## **Stage 2 – Martin Place North (SSD 9270) and South Sites (SSD 9326) Over Station Developments**

Thank you for your correspondence dated 8 October 2018 which invites the City of Sydney ("the City") to provide comment on State Significant Development (SSD) Applications 9270 and 9326.

The City has reviewed the stage 2 detailed applications for over station tower developments and based on the submitted information **objects** to the proposals in their current forms.

**Stage 2 SSDA Shadow Study – North Site**

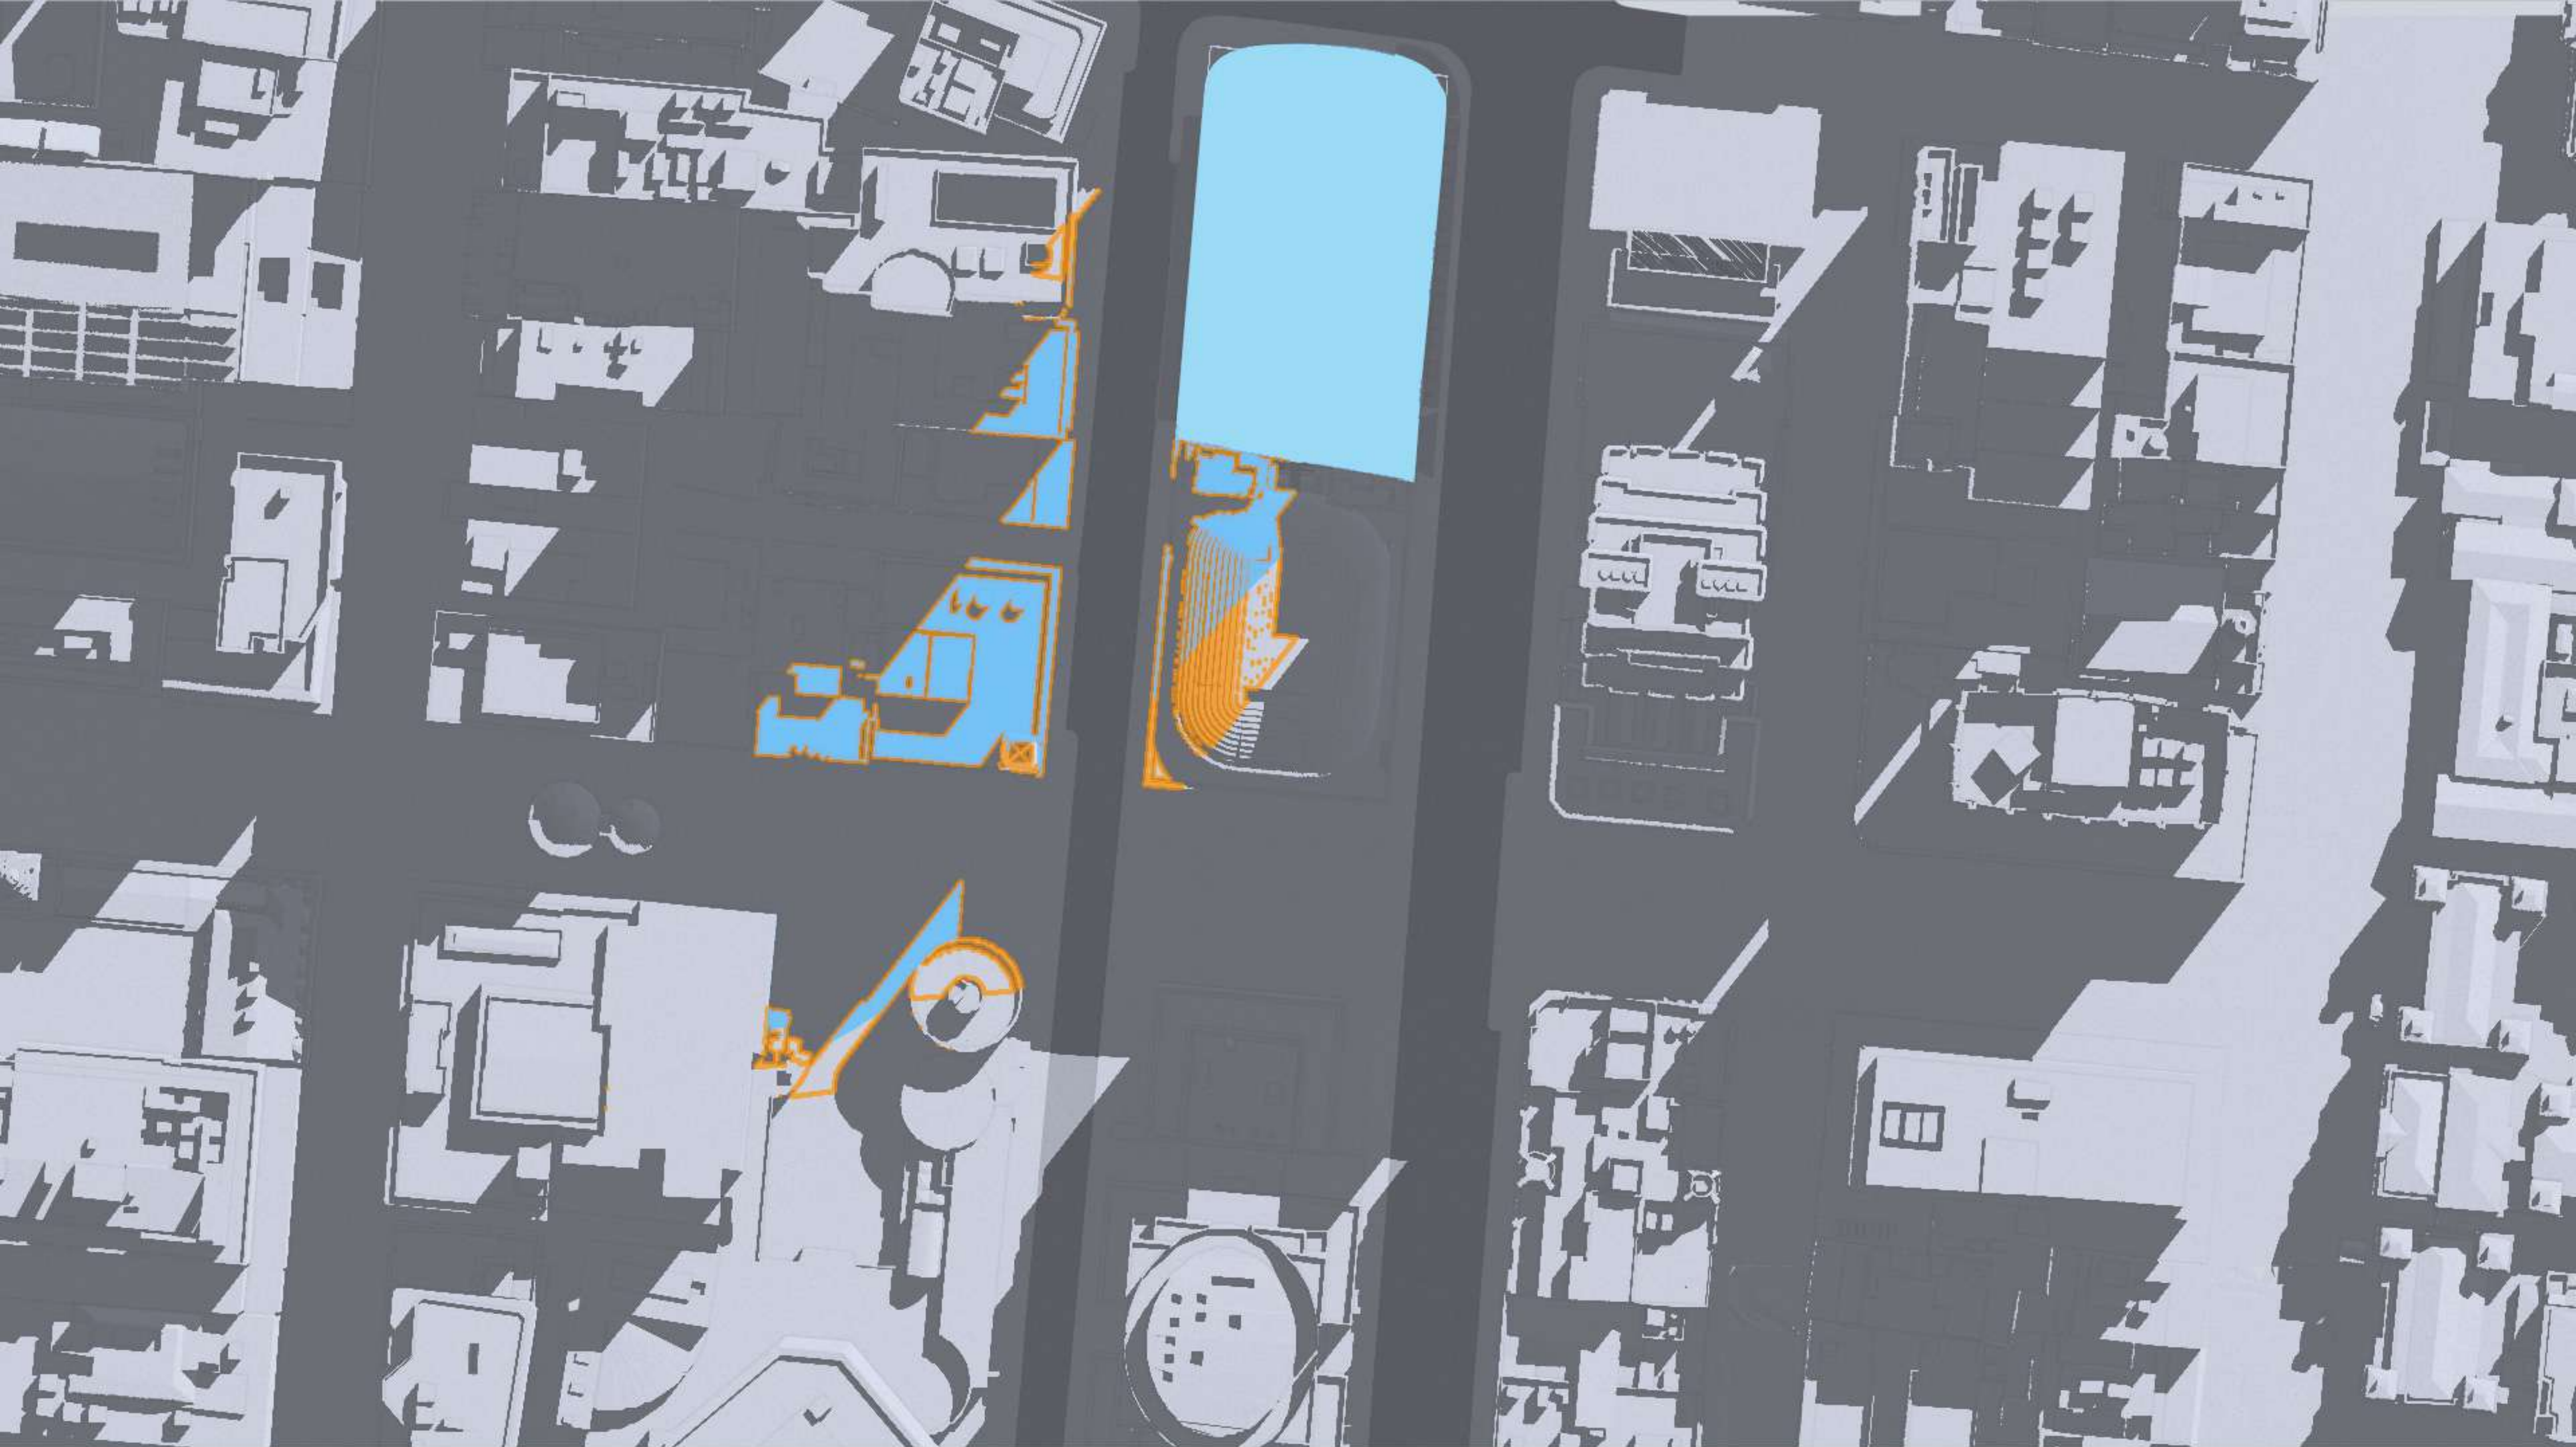
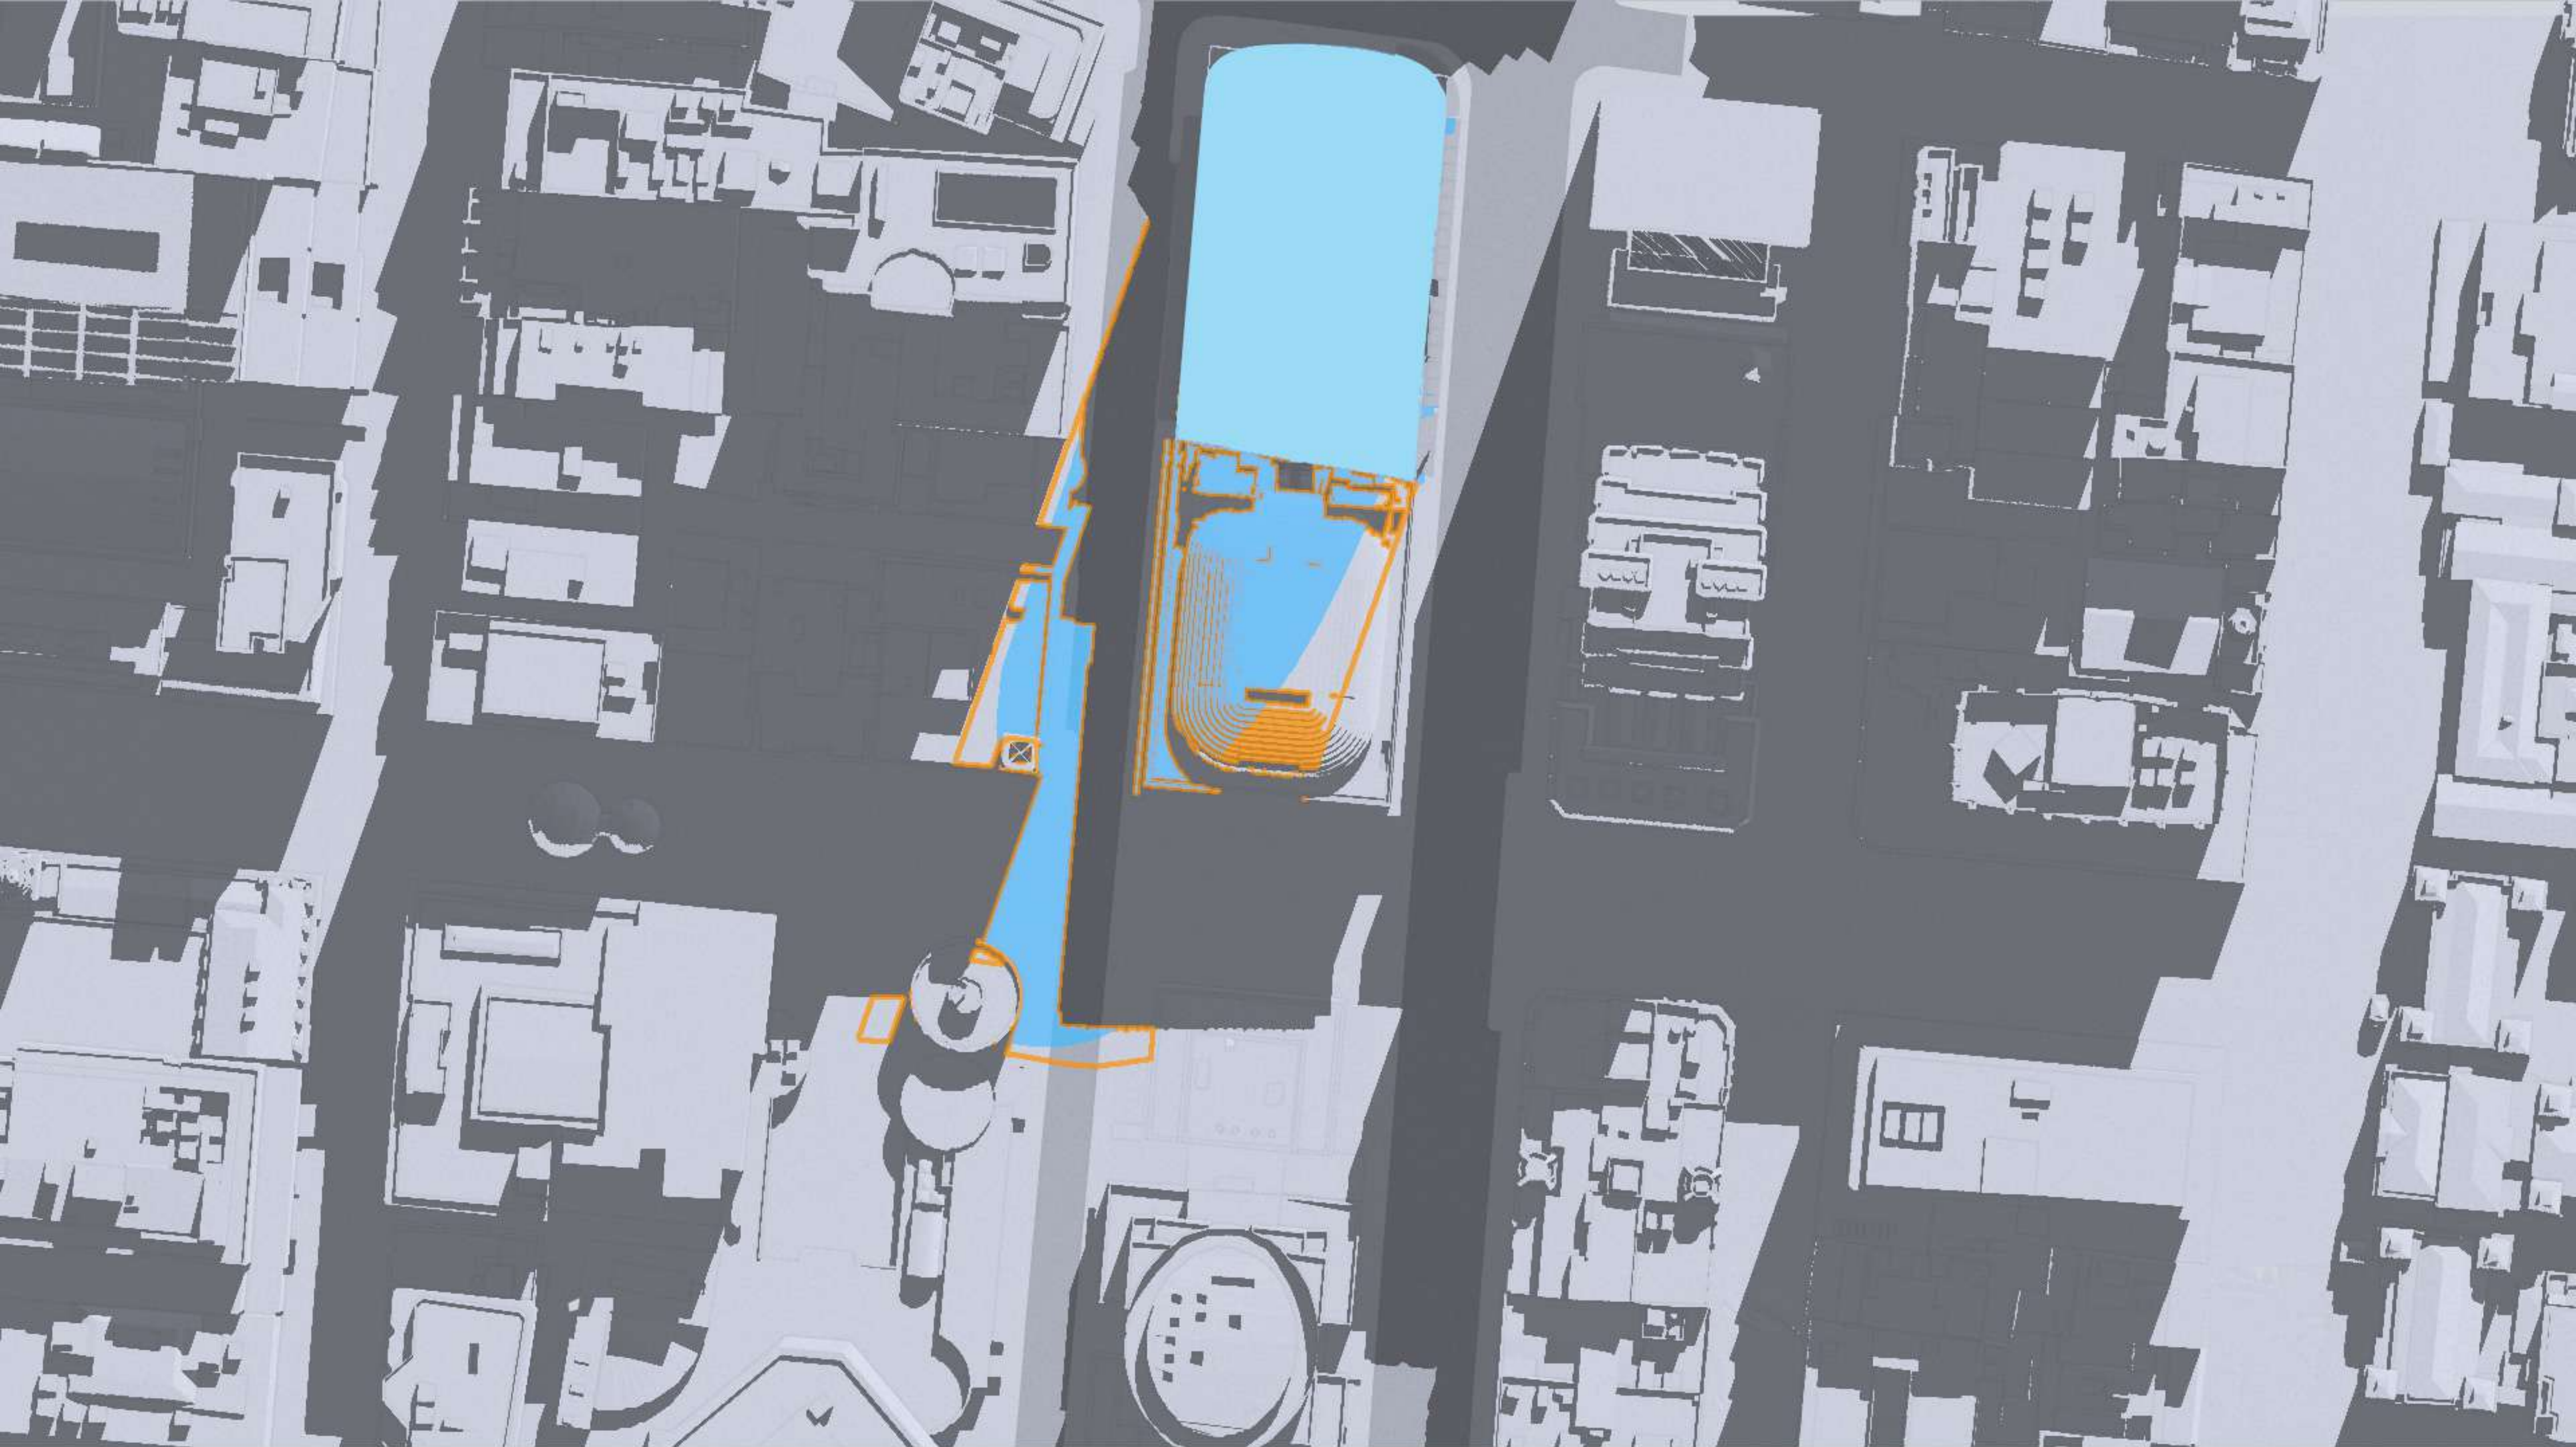
The proposed building form of the north tower is incongruous to the character of central Sydney and the Martin Place Special Character area. The City recommends that the northern tower be setback by at least 8m from all street frontages above the podium height of 50 Martin Place. In particular a setback above the podium is essential for Elizabeth Street frontage to address overshadowing of Martin Place which is avoidable.
